Transport
for NSW

**State Significant Development – Norwest Private Hospital Expansion,
11 Norbrik Drive, Bella Vista (SSD 13_6074) Notice of Exhibition**

Thank you for your letter dated 6 December 2013 requesting Transport for NSW review and comment on the above State Significant Development.

Job Name: Norwest Private Hospital
Sketch Name: Traffic Management During Construction Sequencing
Date: 14/10/2013
By: D. Clements
Job Number: 131528
Sketch Number: SK110

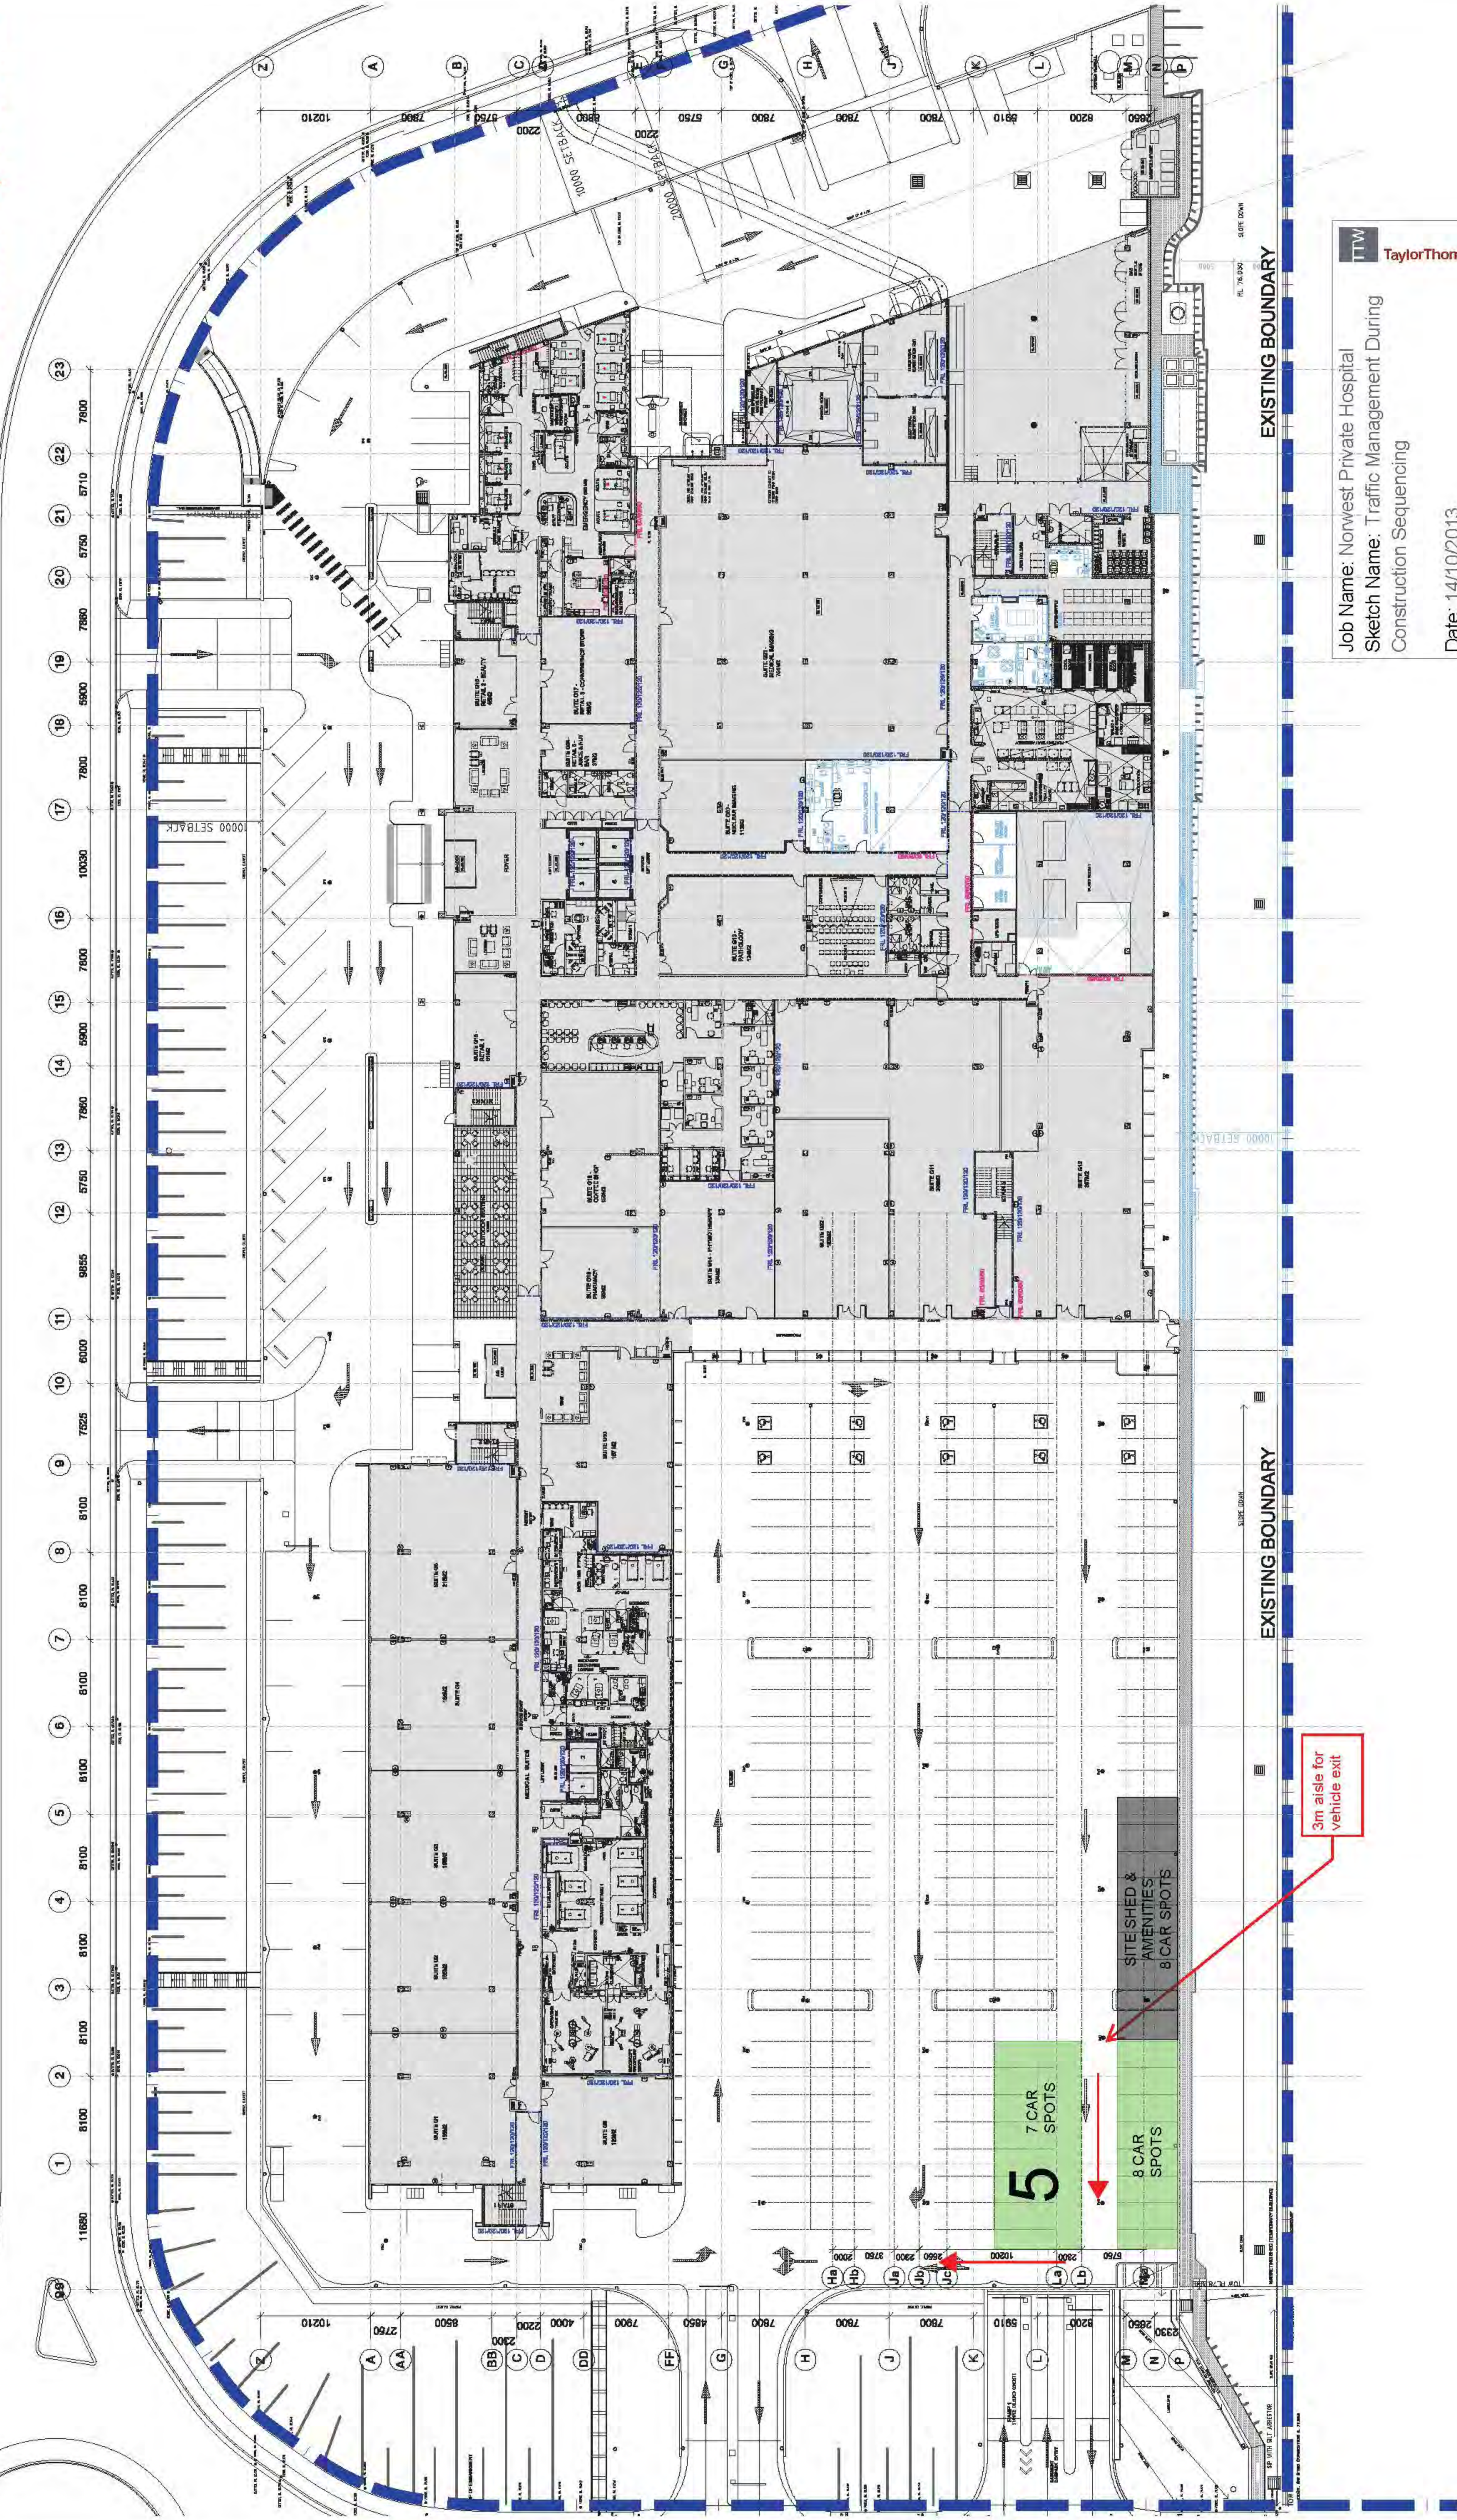
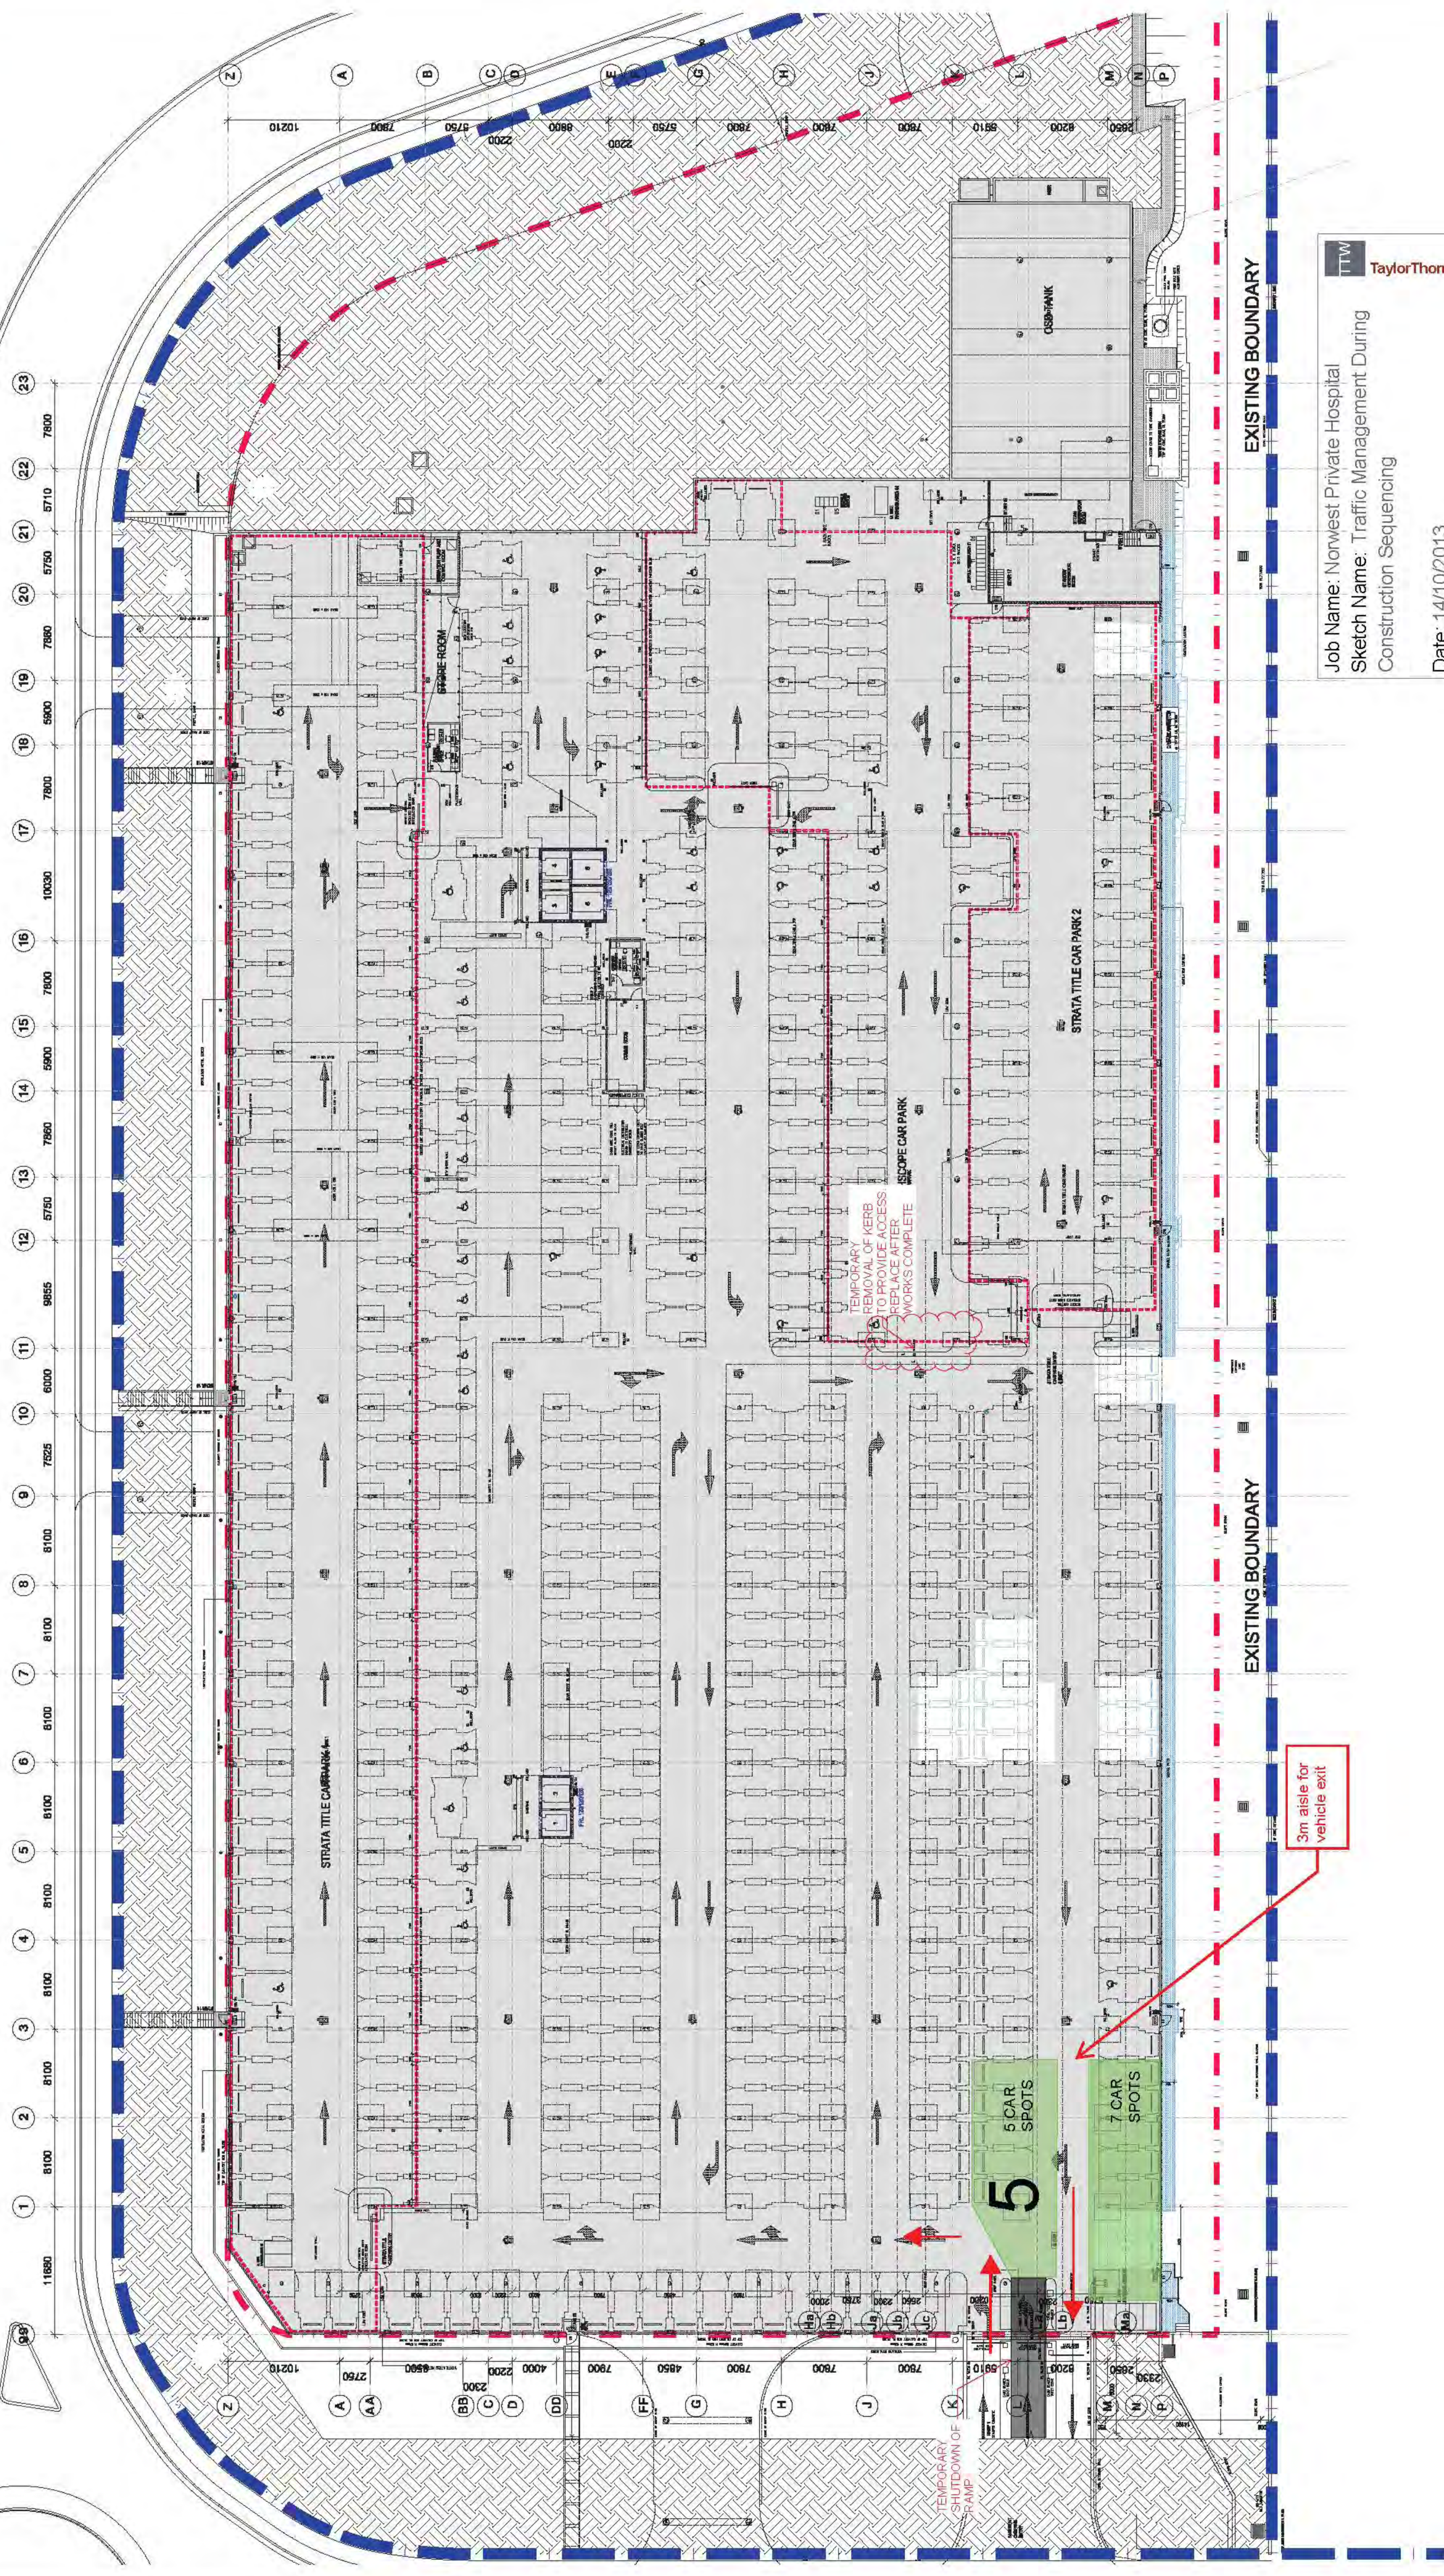
- Conditions of development consent should include the need to prepare a Traffic Management Plan for Construction Activities (TMP), which should detail construction vehicle routes, number of trucks, hours of operation, access arrangements and traffic control measures to undertaken during the construction phase of the project. The TMP should be submitted for review and approval prior to commencement of any works on site.

- The TMP does not provide information on the potential construction traffic impacts to bus services operating within the vicinity of the site. Transport for NSW considers that it is likely there would be impacts to bus services as the proposed construction vehicles route around the hospital site is the same as that for bus services. Transport for NSW recommends that any development approval include a condition that the construction of the hospital expansion be undertaken in a manner that does not create any safety concerns and minimises disruption for bus services.
